City of Portland, Maine - Building or Use Permit Application
 389 Congress Street, 04101 Tel: (207) 874-8703, Fax: (207) 874-8716

Permit No: 06-0714	Issue Date:	CBL: 171 A011001
------------------------------	--------------------	----------------------------

Past Use: Commercial/Residential	Proposed Use: Converting portion of the existing commercial space to an apartment & add a new bathroom (first floor)	Permit Fee: \$348.00	Cost of Work: \$28,000.00	CEO District: 4
Proposed Project Description: Converting portion of the existing commercial space to an apartment & add new bathroom (first floor)		FIRE DEPT: <input type="checkbox"/> Approved <input type="checkbox"/> Denied	INSPECTION: Use Group: Type	
		Signature:	Signature:	
PEDESTRIAN ACTIVITIES DISTRICT (P.A.D.)				
Action <input type="checkbox"/> Approved <input type="checkbox"/> Approved w/Condition <input type="checkbox"/> Denied				
Signature: Date:

FIRST FLOOR PLAN

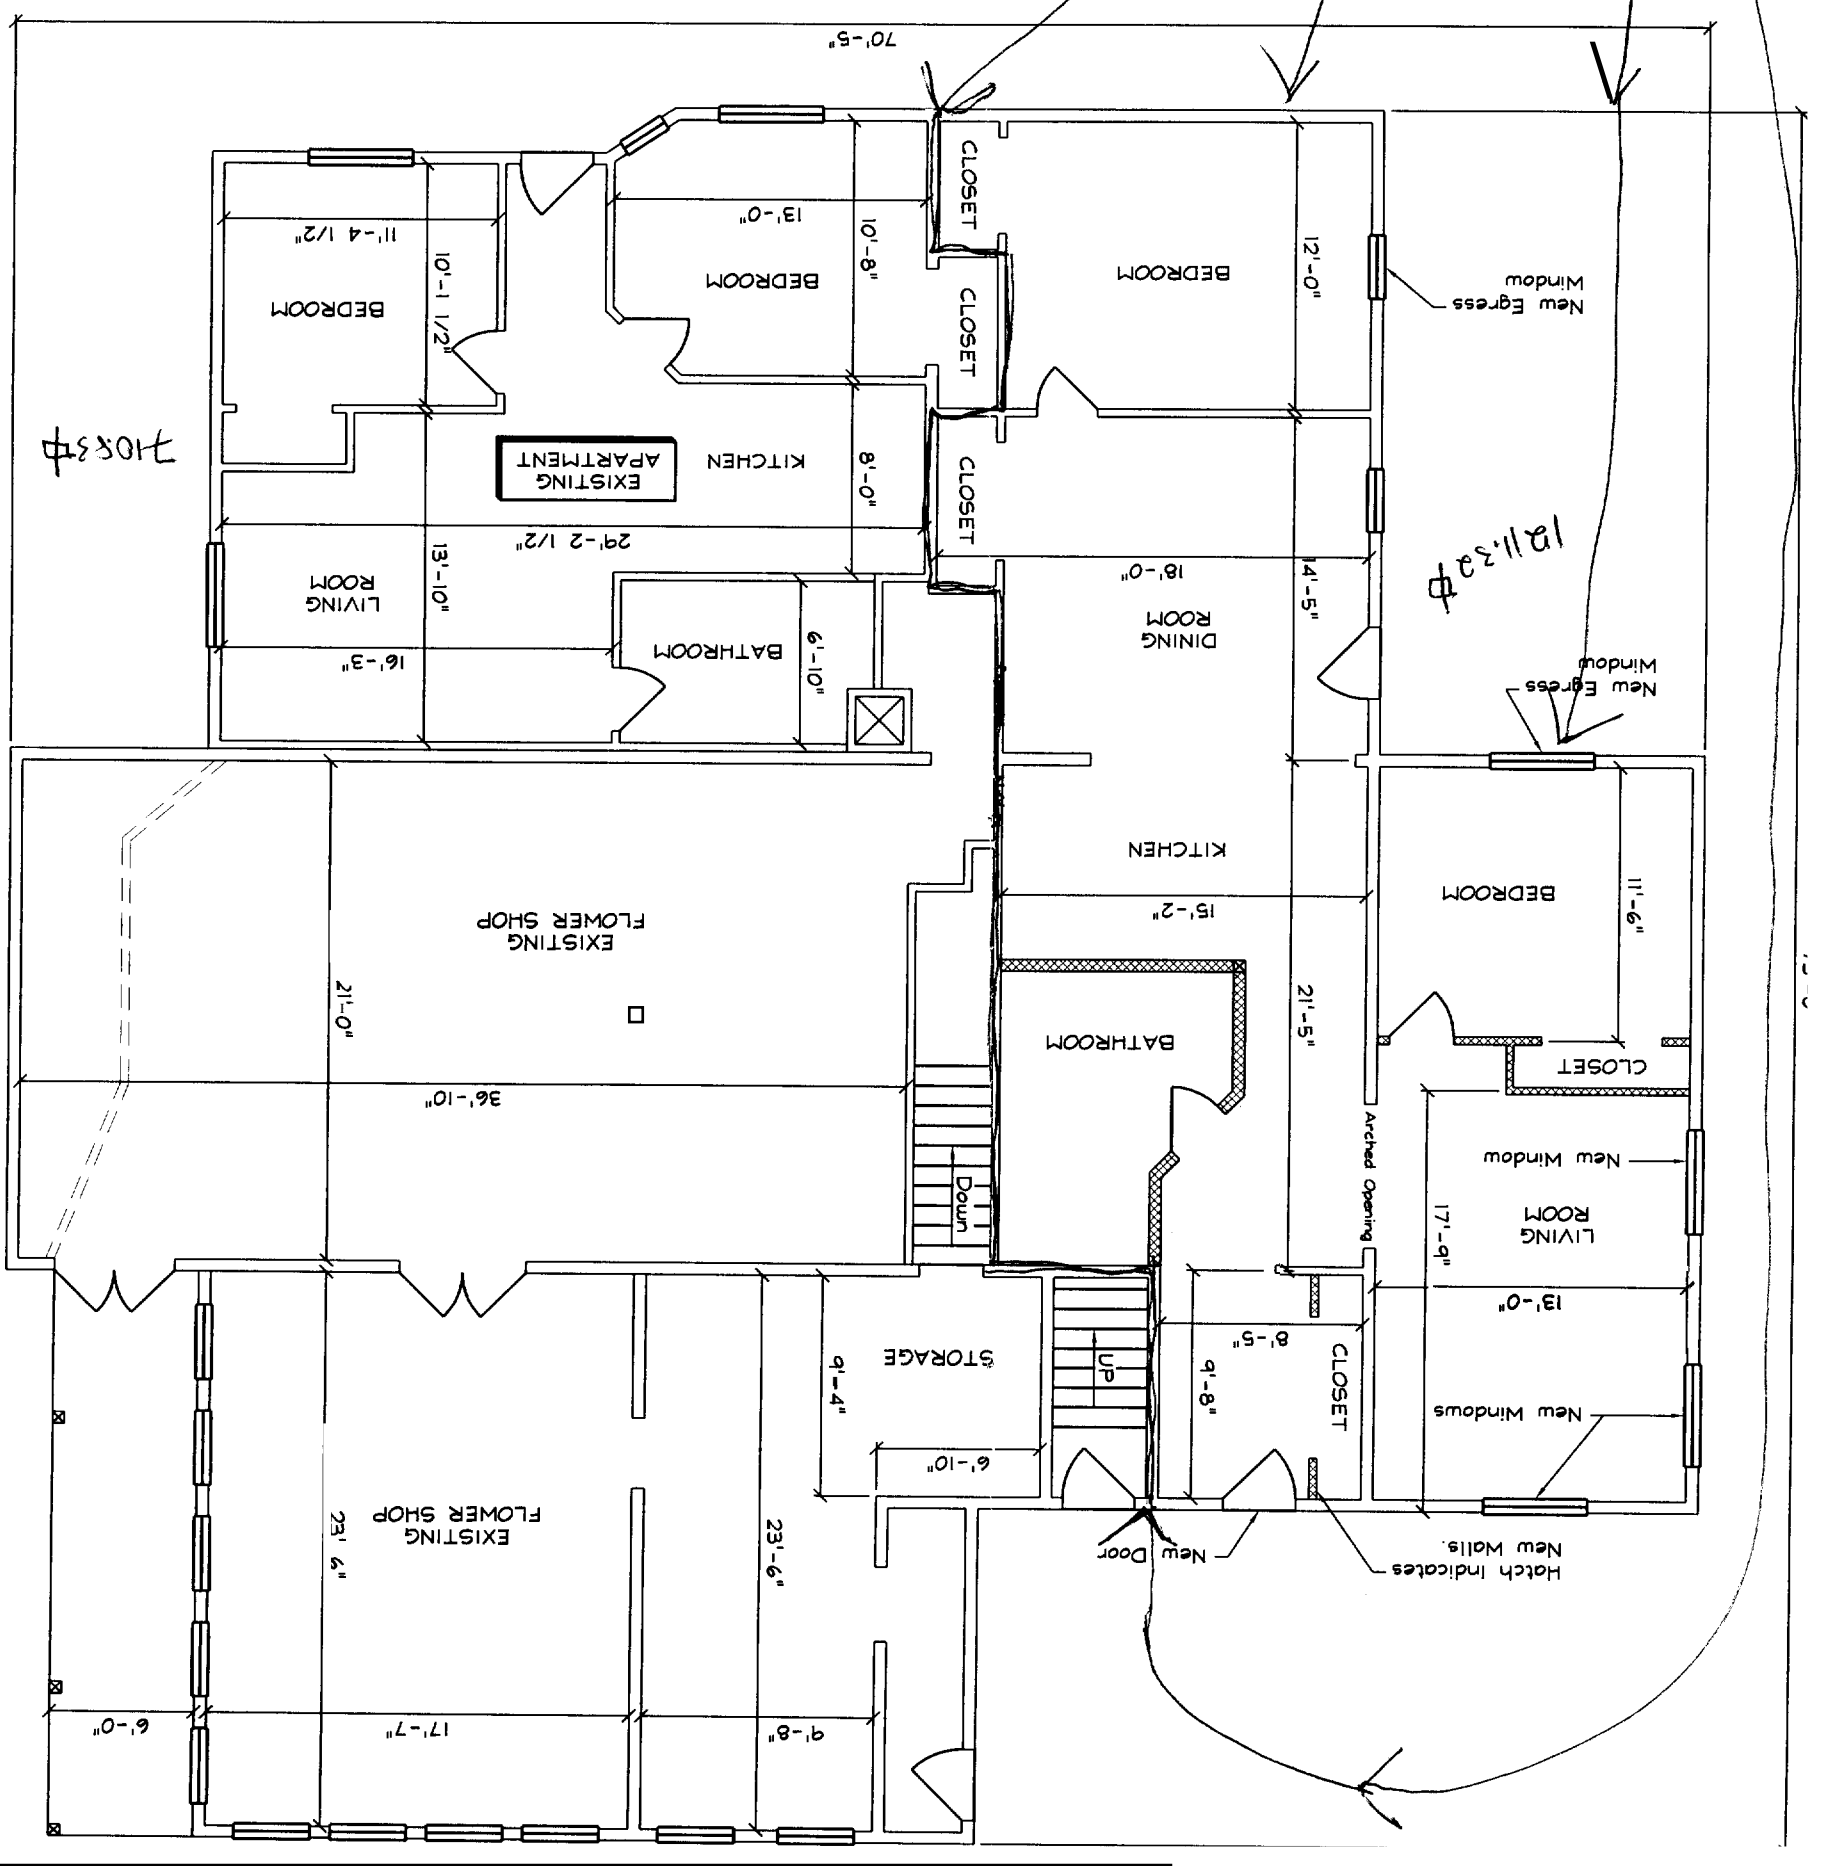
1) Dwelling units must be separated from one another with a One hour Fire rated assembly and a sound transmission rating of 50 or greater. The Owner has agreed , and a UL listed assembly is being provide as part of the permit issuance information.			
Dept: Fire	Status: Approved with Conditions	Reviewer: Cptn Greg Cass	Approval Date: 05/31/2006
Note:			Ok to Issue: <input checked="" type="checkbox"/>

Comments:
6/6/2006-mjn: need details for landings, fire separation assemblies and egress windows.
6/15/2006-ldobson: Dropped off additional information rerouted to MJN
